Statement to support Application for removal or variation of a condition following grant of planning permission – Residential Development, Whalley Road Sabden.

This application is to seek approval to remove the sycamore tree reference T21 as detailed in the Bowland Tree Consultancy Ltd Arboricultural report in support of pre-commencement condition 10.

Drawing Name:
Site Plan As Proposed

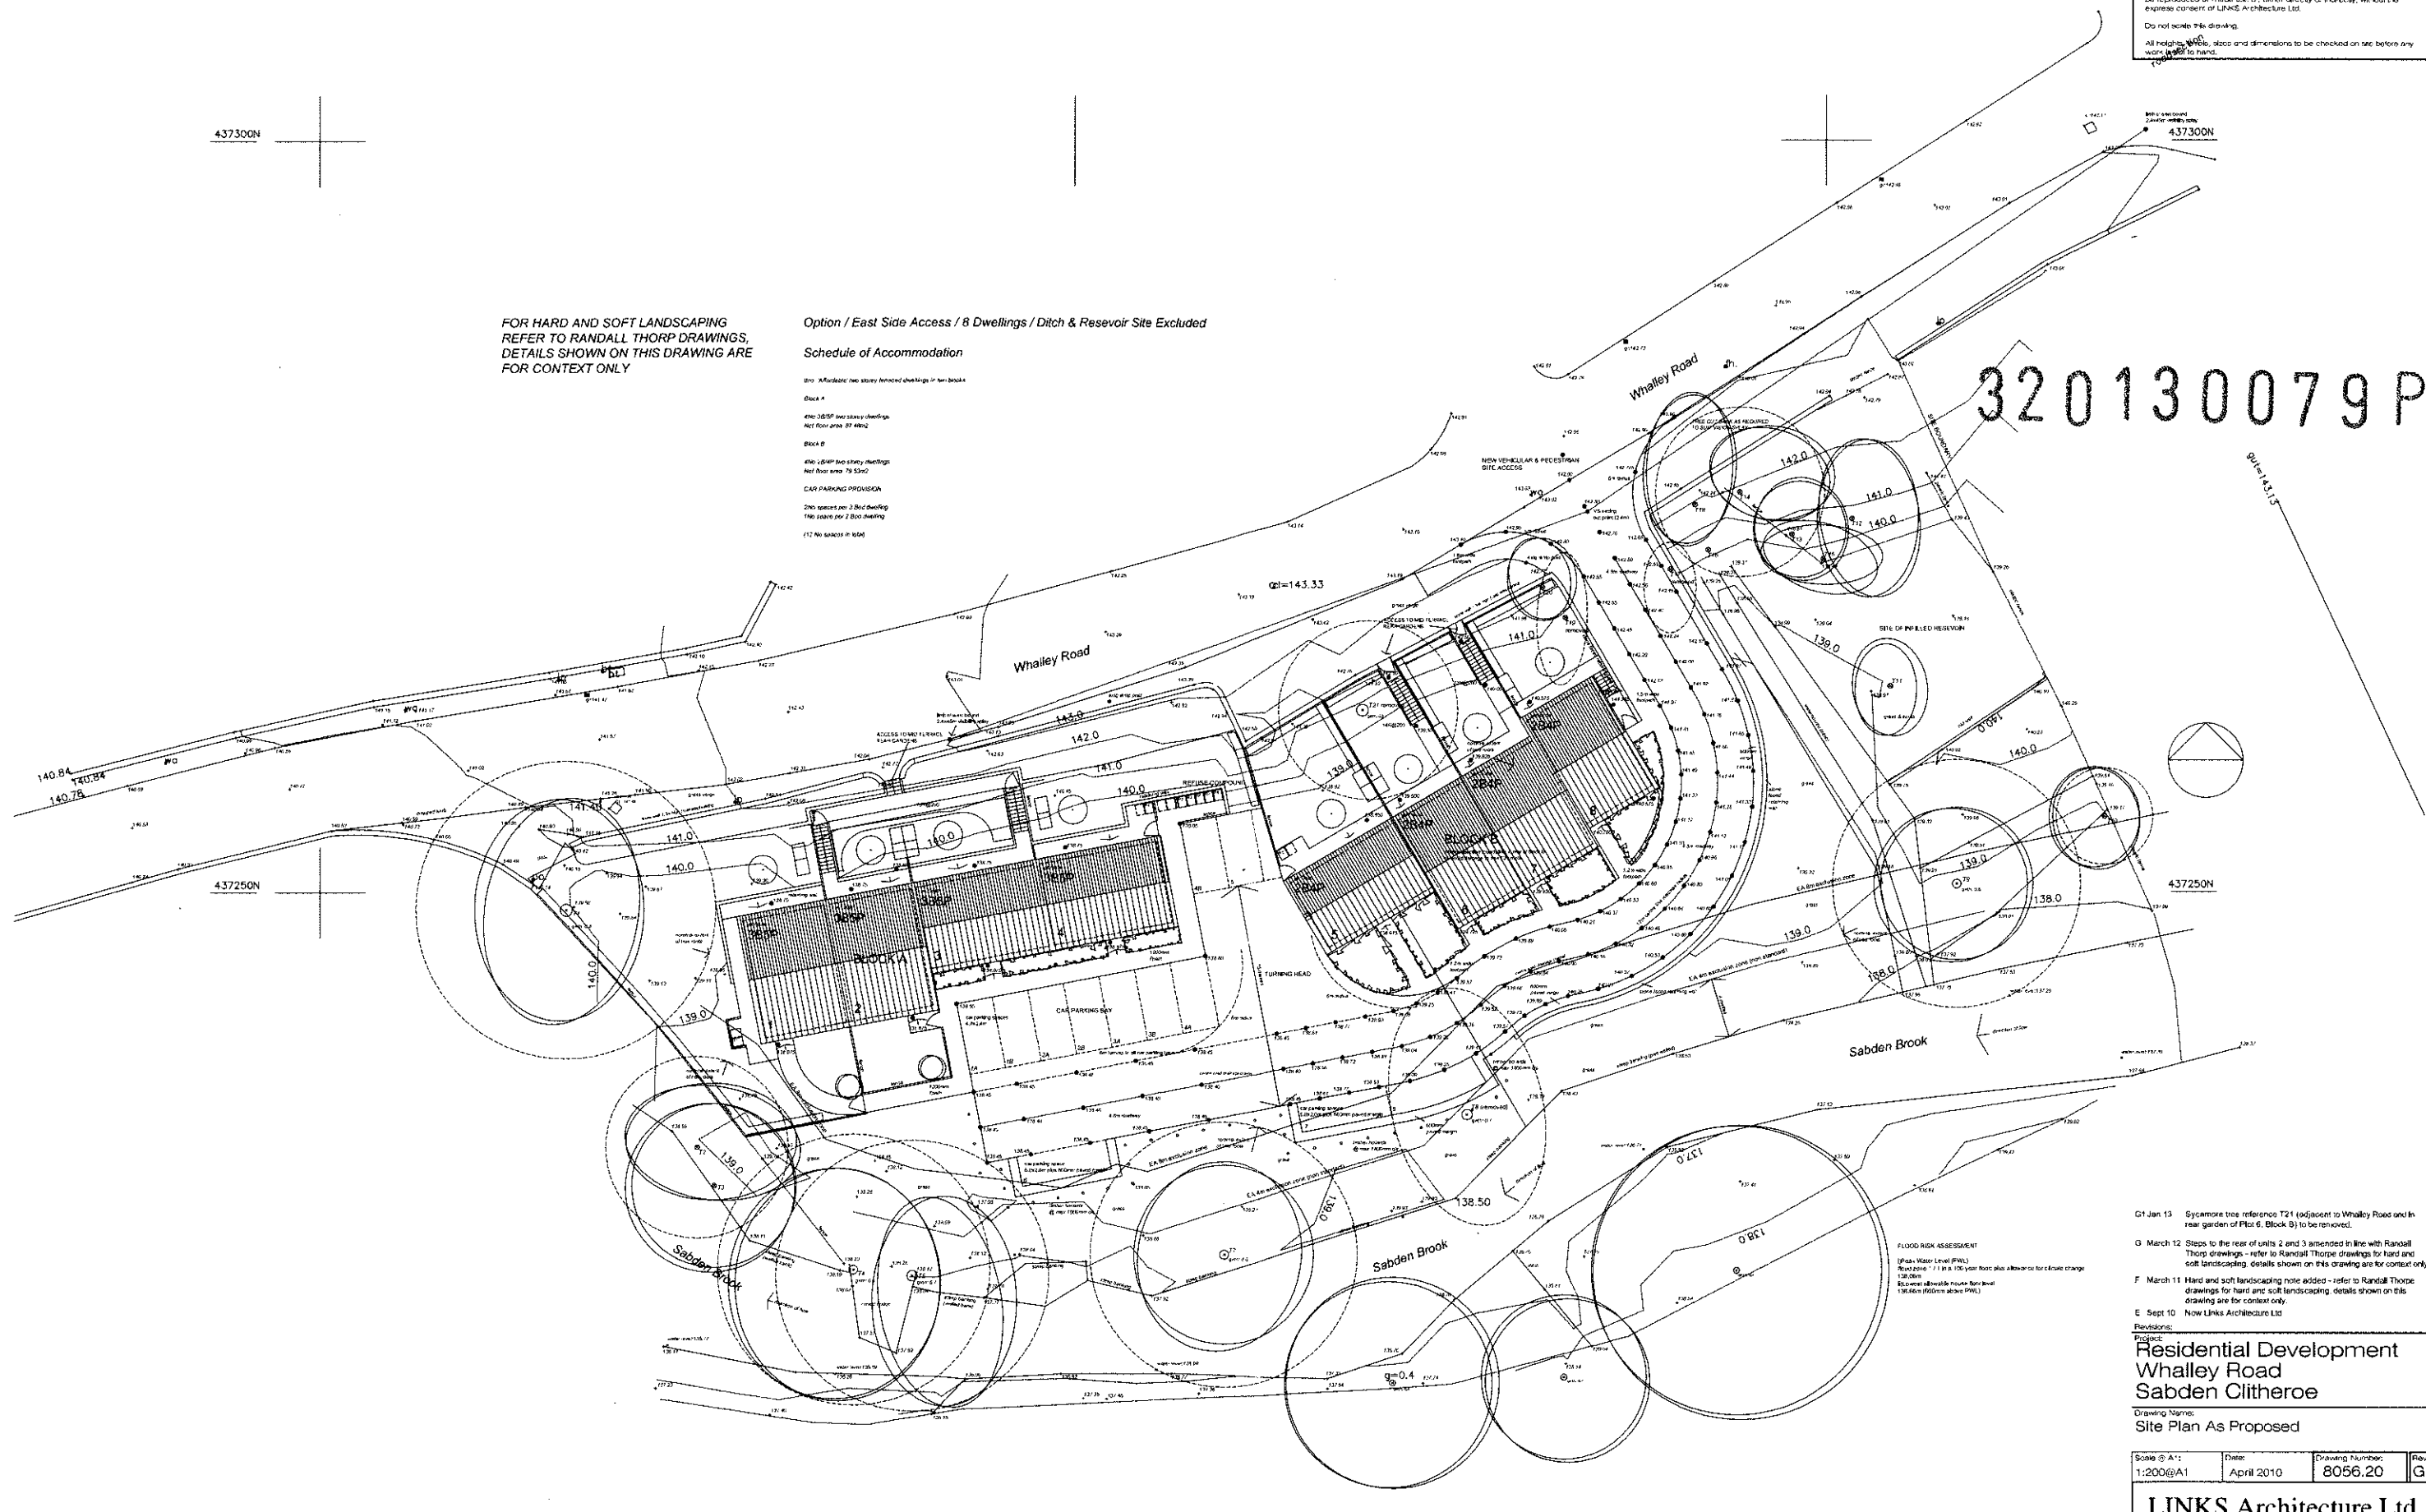
The retaining structures required to form the approved gardens and Highway retention would be within 3 m of tree T21, and would seriously compromise the root zone. The formation of the retaining structure would require the removal of the knot weed before excavation. Therefore, the only viable option to form the retaining structures, and to comply with the planning condition to remove the knot weed, would be to remove tree T21.

There are also problems with access to the rear of plot 6 as the approved scheme which shows an external flight of stairs leading to the Highways verge has had to be redesigned to meet the maximum rise and going as stipulated in approved document M. This has resulted in a dog legged staircase that turns through the area where the tree is currently situated.

The rear gardens and rear elevations to plots 5, 6 and 7 in Block B, which have the benefit of planning approval, will be shaded by the tree canopy. This will be detrimental to the occupants enjoyment of their gardens as little will grow and will considerably reduce natural daylight levels in the rooms with a

rear (north) facing aspect. Plot 6 will be severely affected by tree T21 in this respect as the canopy will be very close to the rear elevation and will extend over the entire rear garden. The shading of the rear of some of the dwellings by the tree could pose a serious concern for the health of the occupants as it will considerably reduce the available daylight in the properties.
